**Subject: Environmental Impact Statement – Mamre Road Data Centre Campus
(SSD - 92743706) (Penrith)**

CPHR comments on the Environmental Impact Statement – Mamre Road Data Centre Campus (SSD-92743706)

Key Plan:

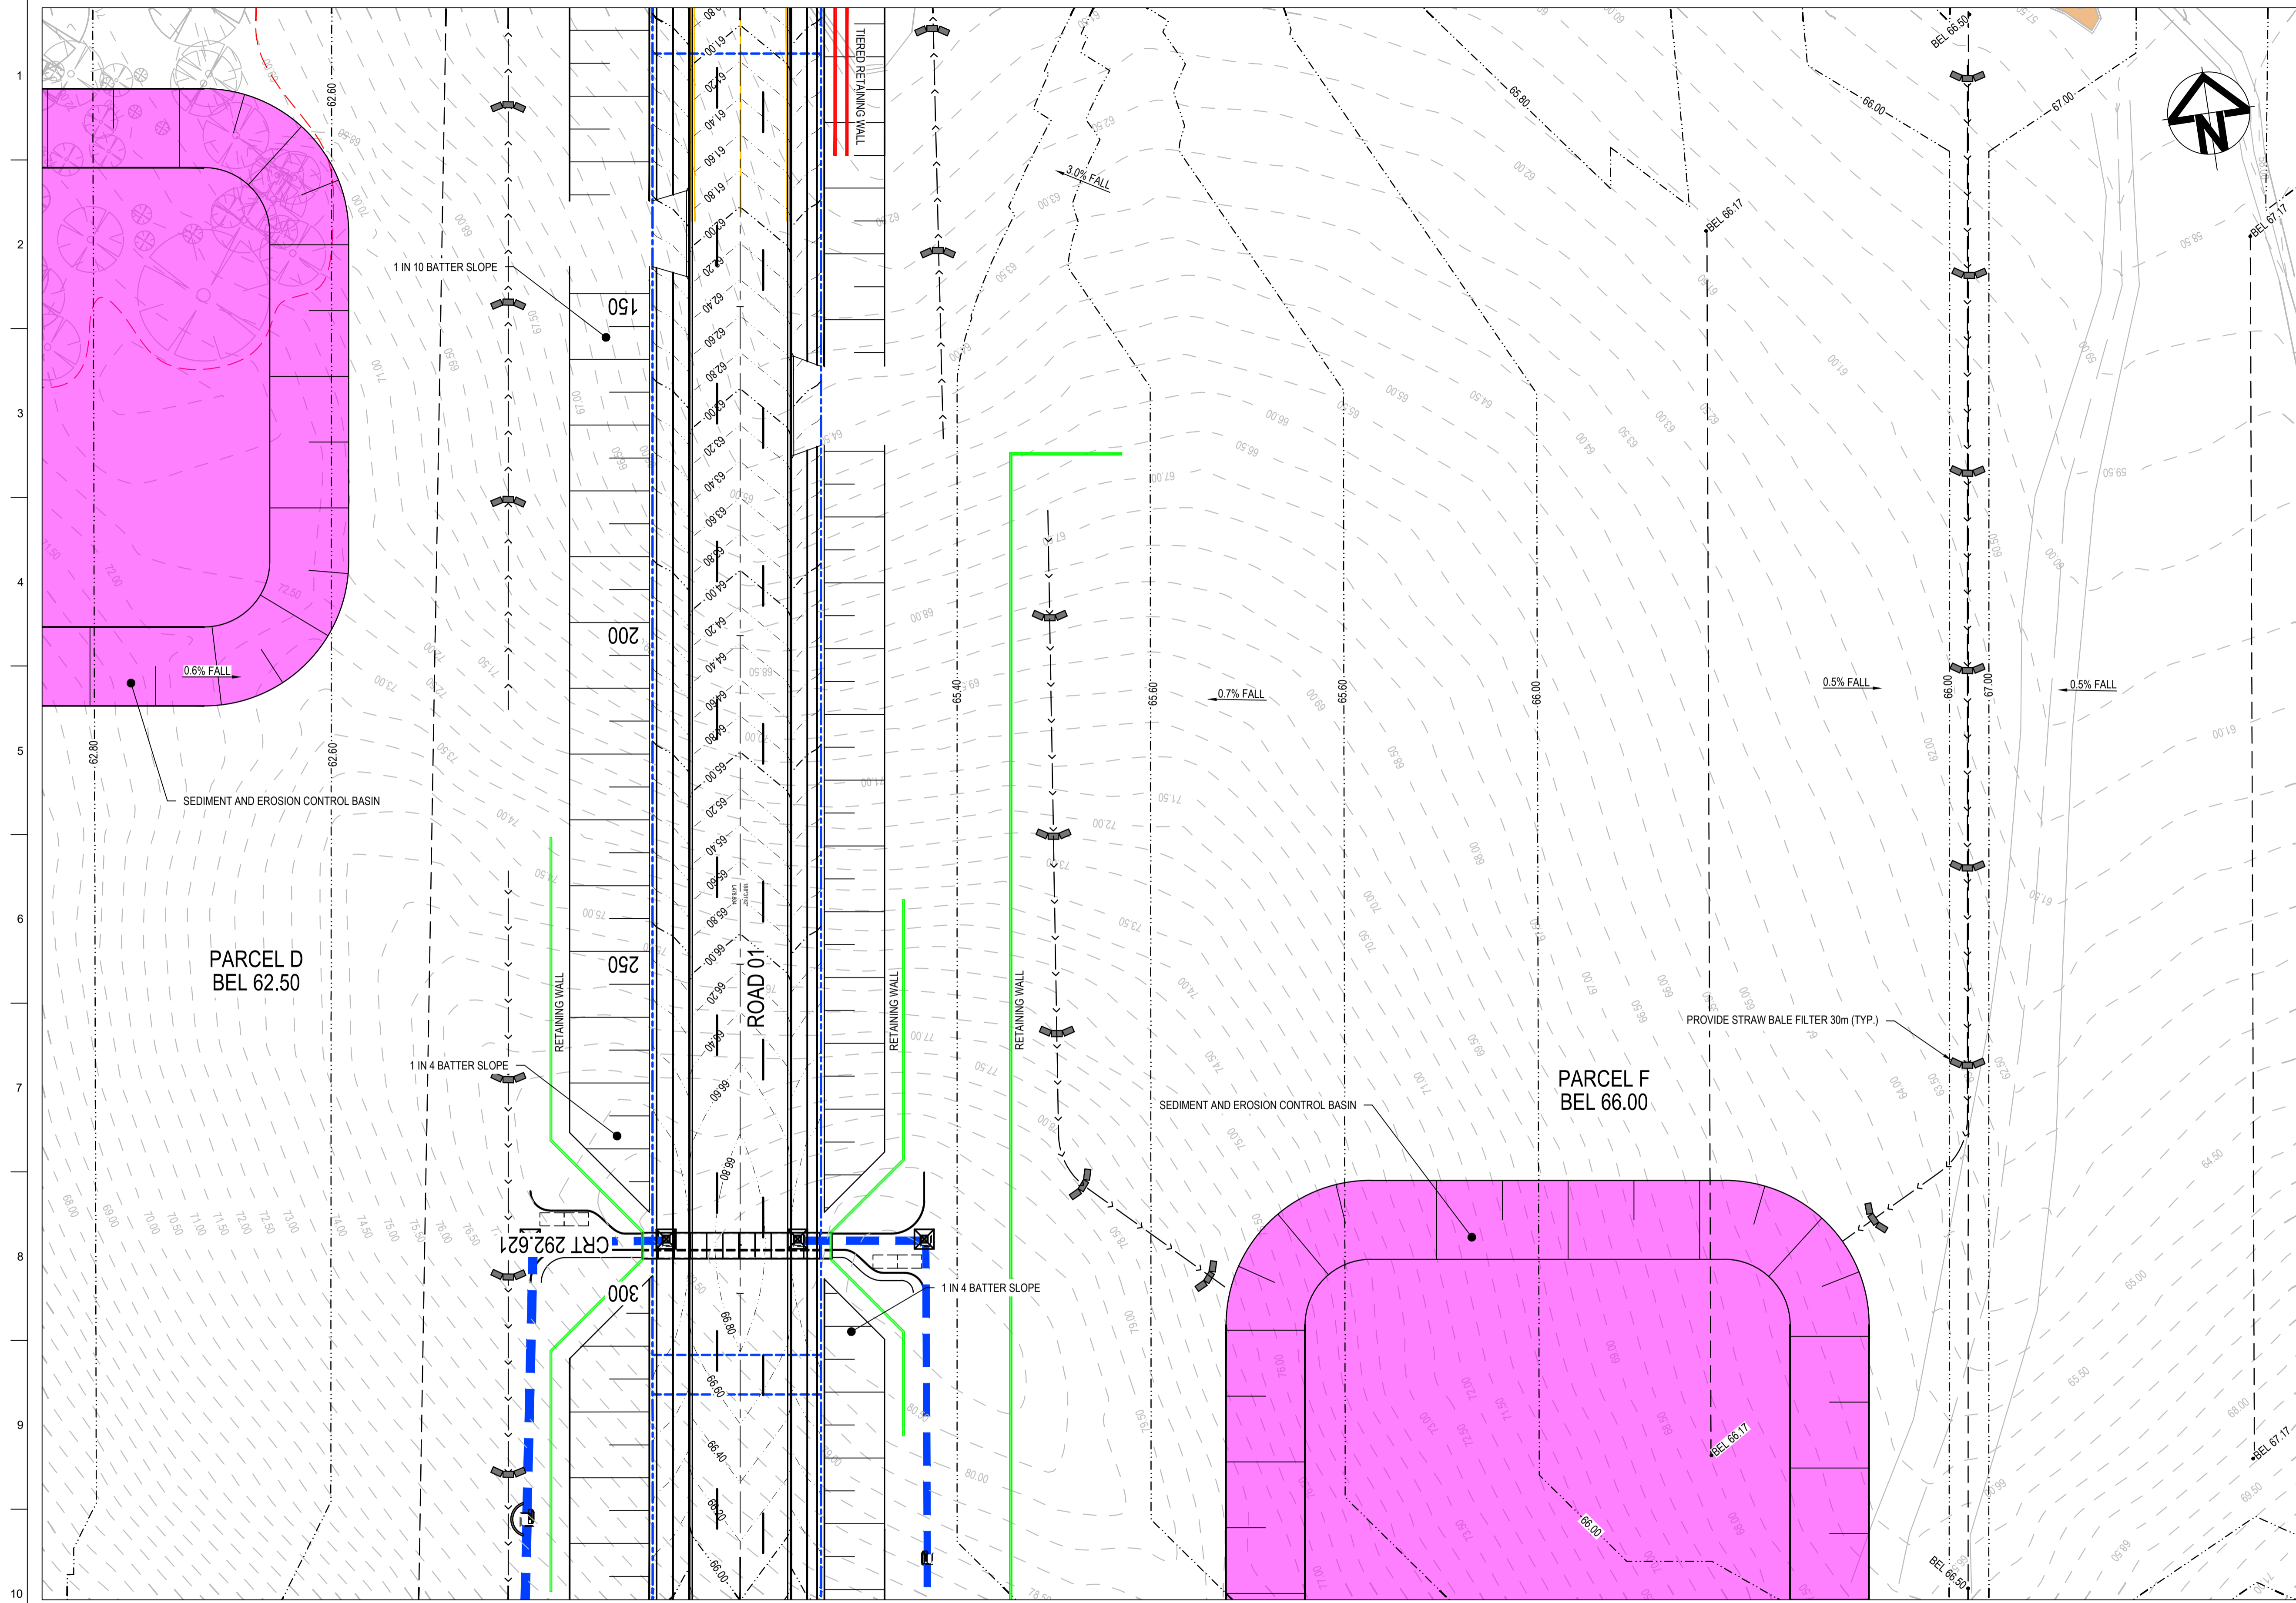
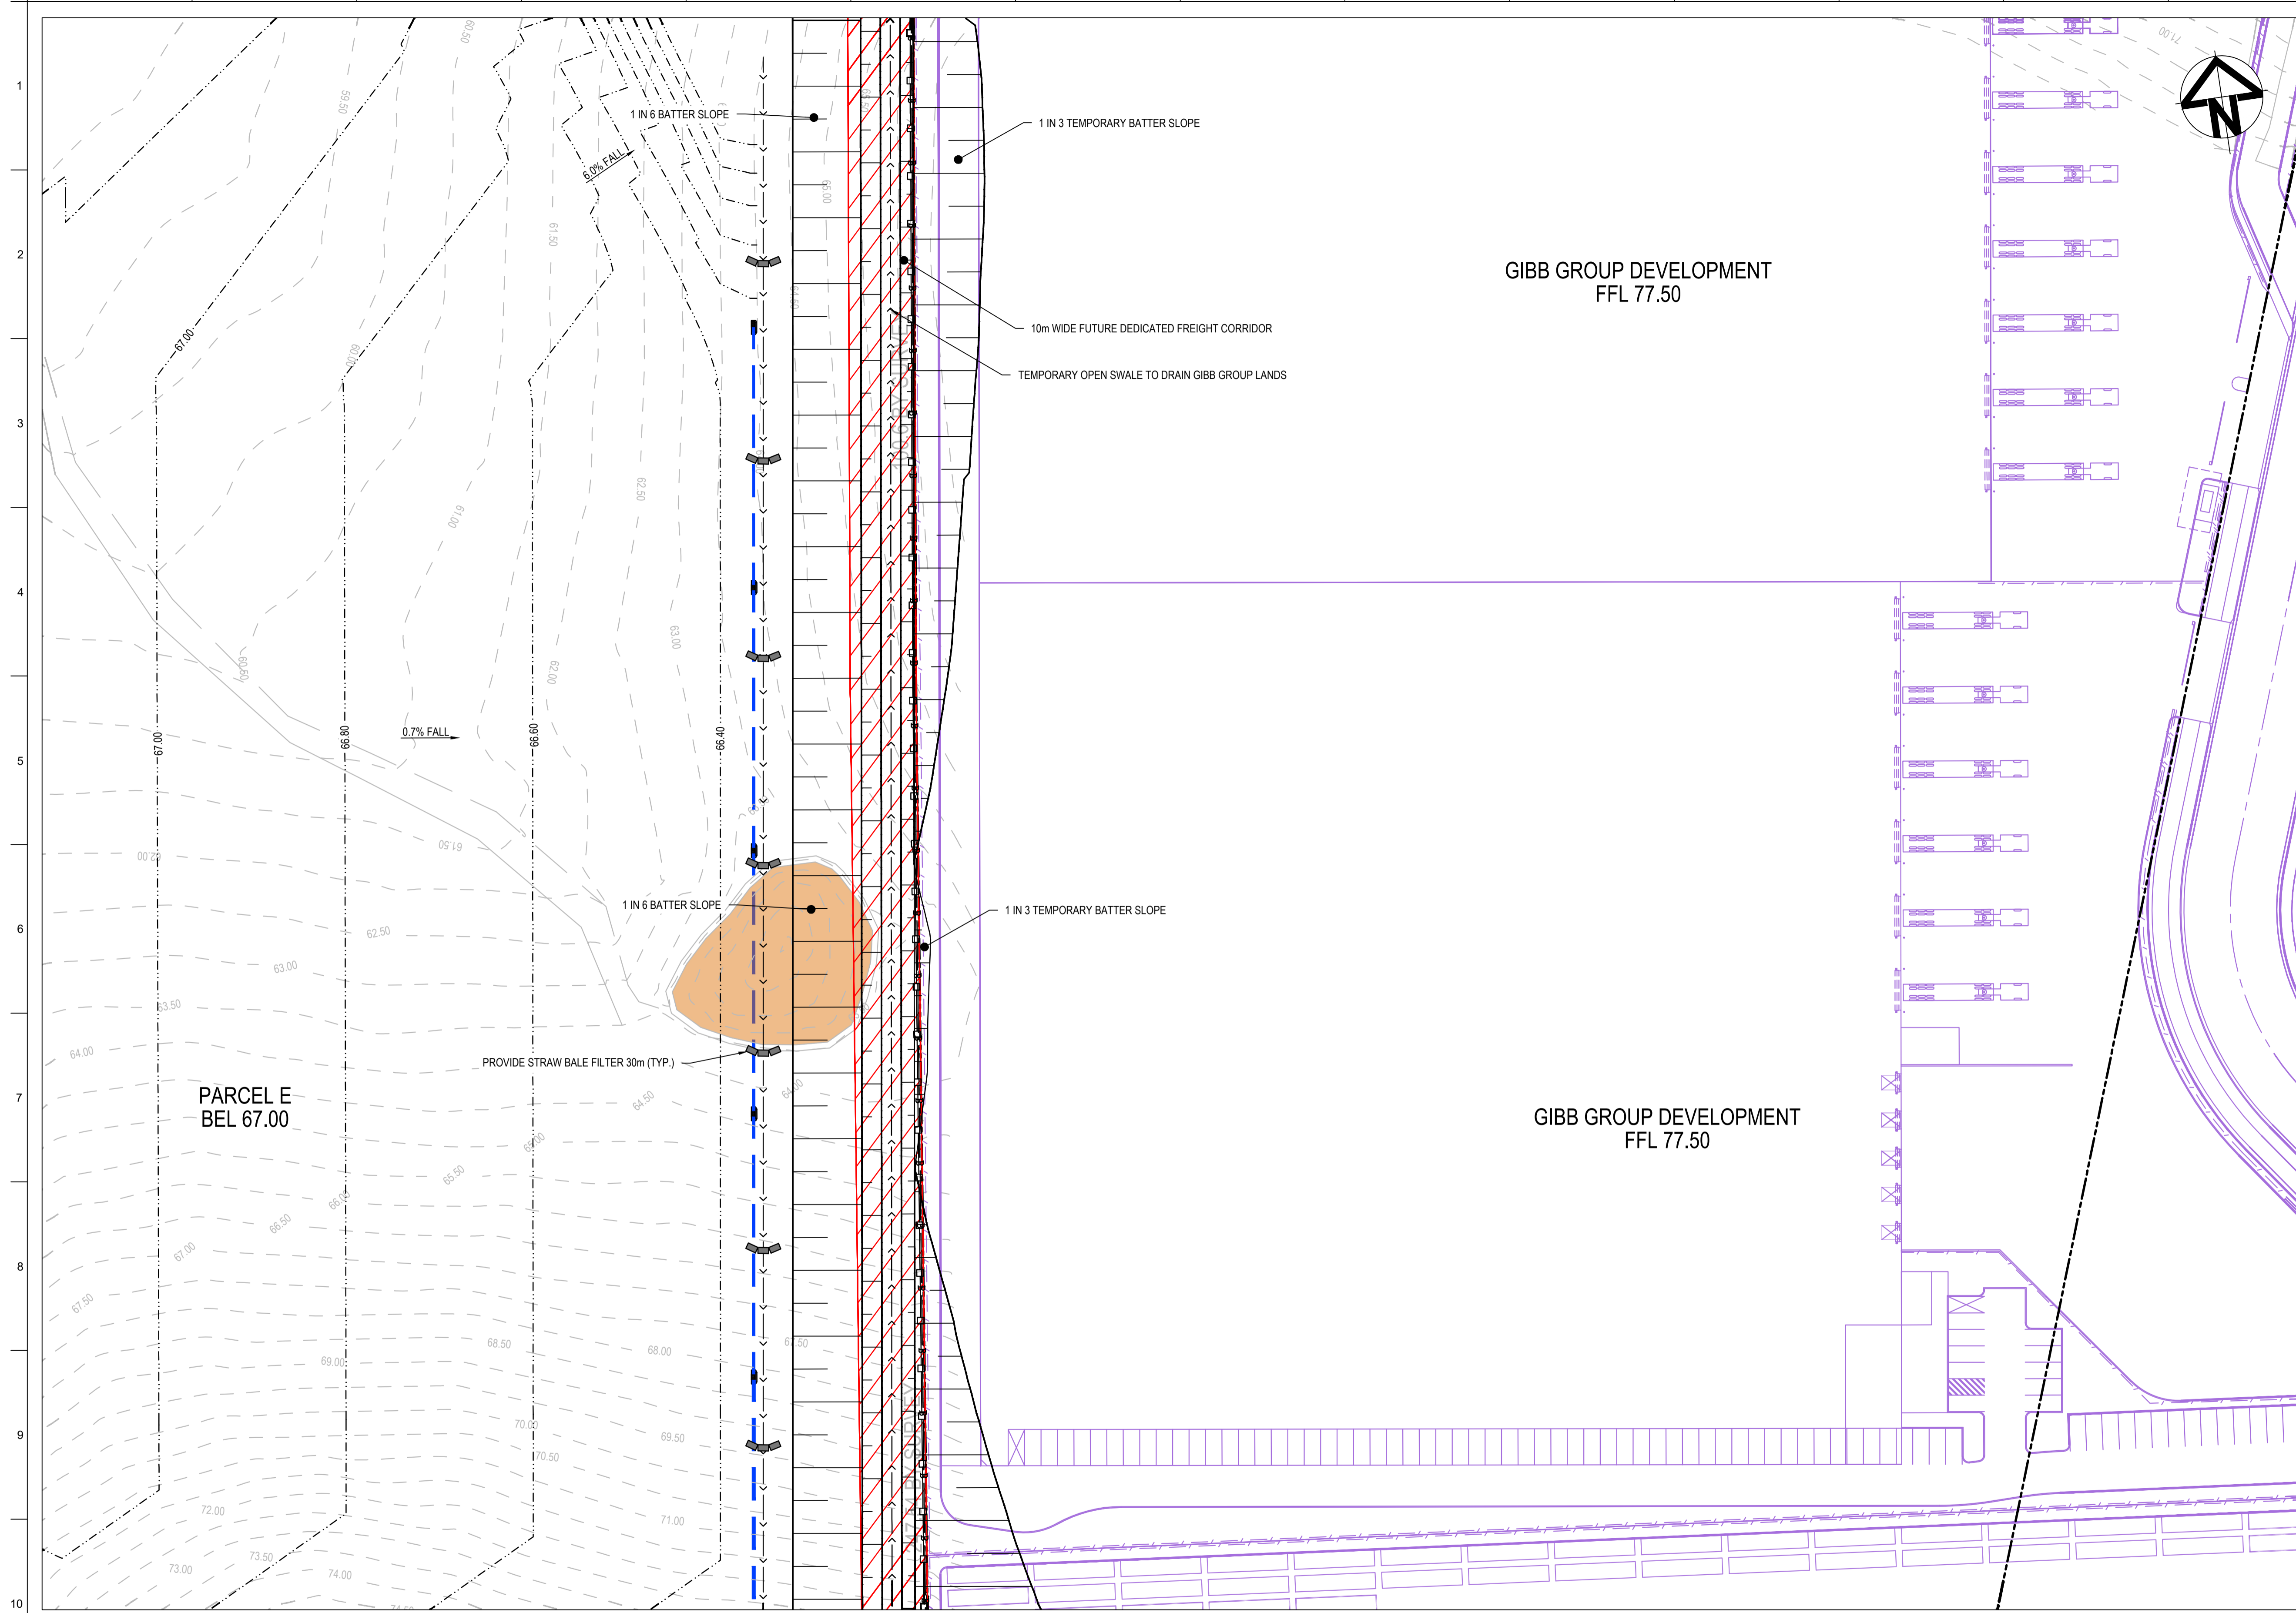
11.	<i>Erosion and Sediment Control Plan (ESCP)</i>	CPHR advises that the ESCP has inadequate details for each construction phase to understand the proposed stormwater strategy. The proposed erosion and sediment control details for all interim phases was also not provided or included in Civil Drawings. For each construction phase a civil drawing with the proposed ESCP measures should be provided. CPHR advises the applicant refer to 805 Mamre Road (SSD-30871587) ESCP as a good example.

Recommended actions: • To demonstrate the construction phase stormwater quality targets are met, a detailed ESCP must: ○ be developed and certified by a Certified Professional in Erosion and Sediment Control, or a qualified and experienced civil engineer with at least 5 years' experience in the development of site-specific soil and water management plans ○ be prepared in accordance with the Blue Book (NSW Government 2004) and water sensitive urban design (WSUD) considerations set out in Chapter 3 of the Technical Guide ○ provide conceptual designs that include the site, catchment and key features of erosion and sediment controls on scaled drawings ○ illustrate appropriate controls, that when implemented will achieve the construction phase stormwater quality targets in Table 2 of the Technical Guide. • As the subject land is larger than 2,500m², the Technical Guide provides best practice initiatives which strengthens requirements from the Blue Book. This involves designing and implementing sediment controls that treat at least 80% of the average annual runoff volume (i.e. 80% hydrological effectiveness) to 50 mg/L total suspended solids (TSS) or less, and pH in the range 6.5–8.5. To achieve these construction phase targets, the design of the basins generally needs to: ○ be sized and operated in accordance with either a Type-A or Type-B sediment basin as documented in <i>Best Practice Erosion and Sediment Control</i> (International Erosion Control Association (IECA), 2008) ○ be provided with an automated system of flocculant dosing and a suitable supply of flocculant/coagulant, with the type of flocculant/coagulant determined based on the <i>Chemical coagulants and flocculants fact sheet</i> (IECA 2018) ○ have markers within each basin to show the maximum sediment storage level and any additional water storage capacity for water reuse ○ limit discharge from the primary outlet system to 50 mg/L TSS, with a pH within the range of 6.5–8.5 ○ be operational before any disturbance occurs in the catchment upslope of the basin ○ if not using Type-A or Type-B sediment basins provide robust justification to demonstrate use of alternatives.
